**Consultation Response from KC,
Ecology Unit**

2026/92134 Land Adjacent, 2, Ashleigh Dale, Birkby, Huddersfield, HD2 2DL

Discharge condition 3 (method statement for enhancing biodiversity) on previous permission 2022/93757 for erection of two detached dwellings

| PDA 22-116-003. | F |

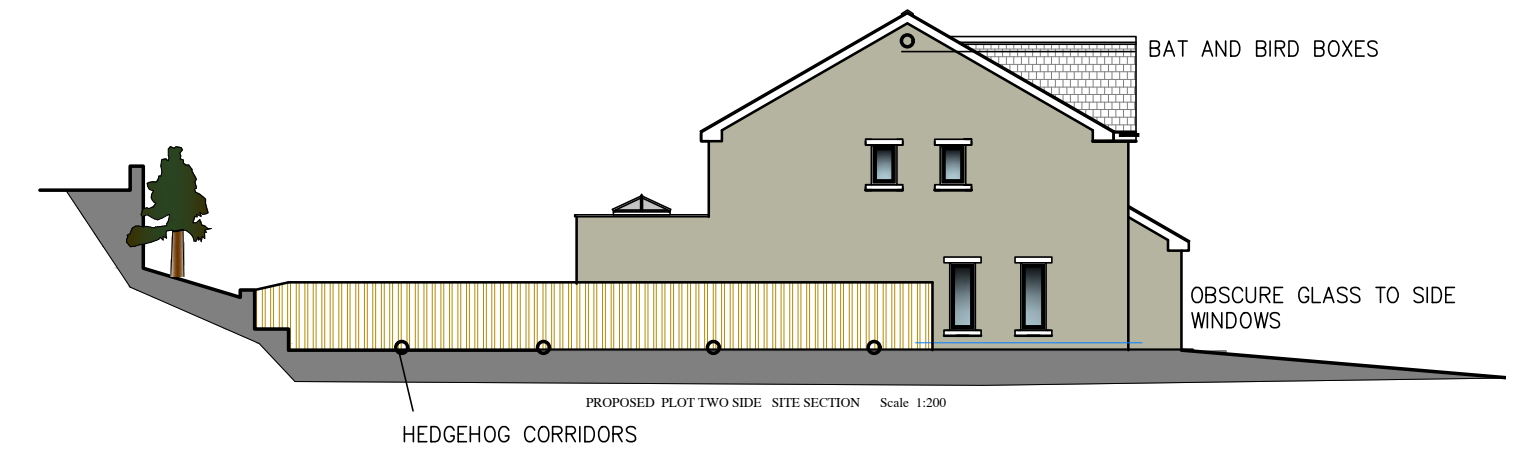
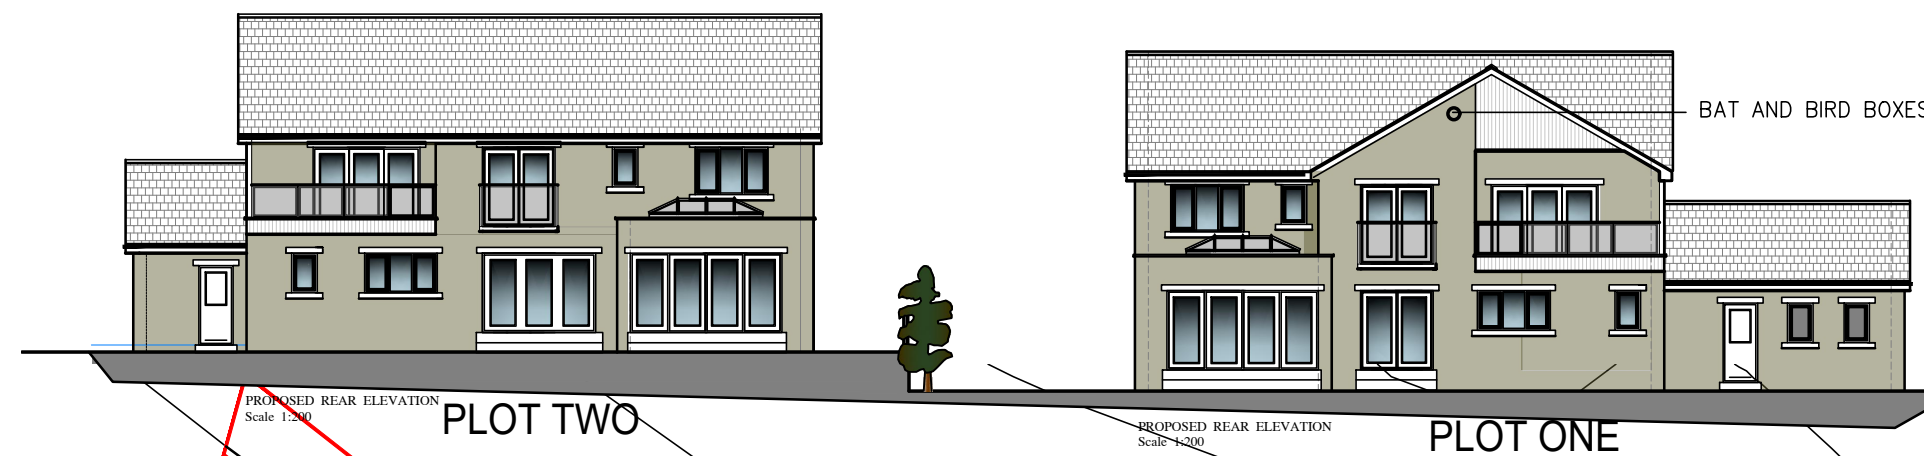
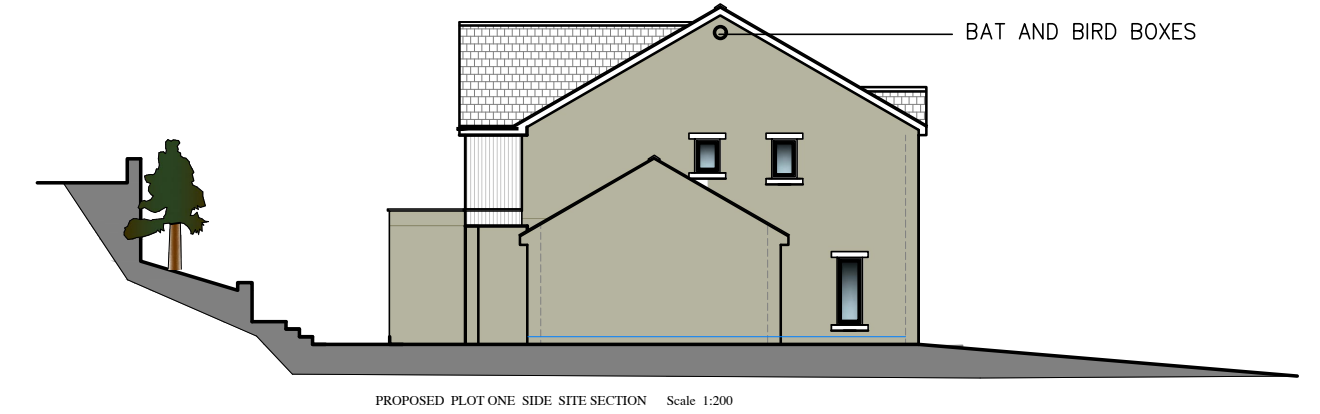
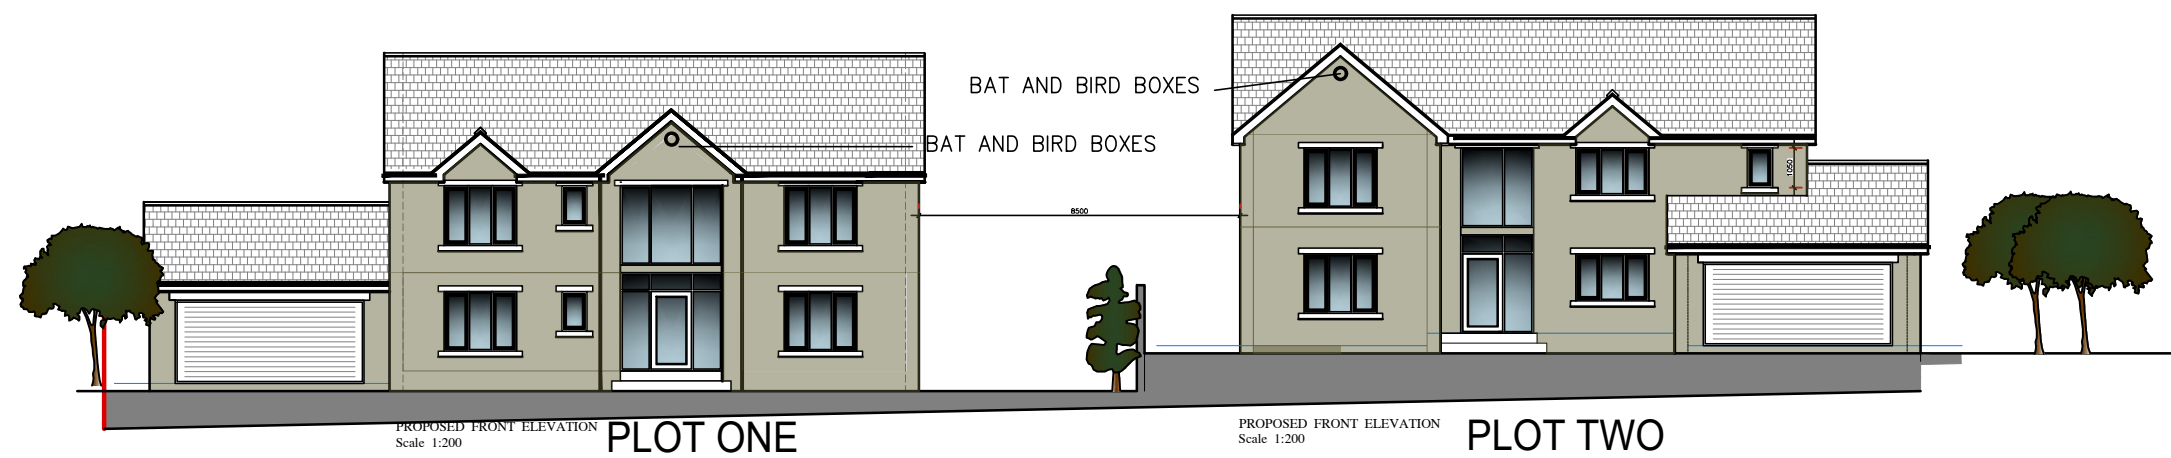
The submitted Biodiversity Enhancement Method Statement details appropriate species-specific enhancements comprising bird and bat boxes, hedgehog highways, and native hedgerows. The Site Plan shows 3 locations on each dwelling for bird/bat boxes, but the method statement details a minimum of 2 of each will be installed. Additionally, the habitat boxes appear to be located generally above windows. Bats can be very sensitive to lighting, so I would recommend that further details on which locations will be bird boxes, and which will be bat boxes, with consideration to the features that these species require, is provided.
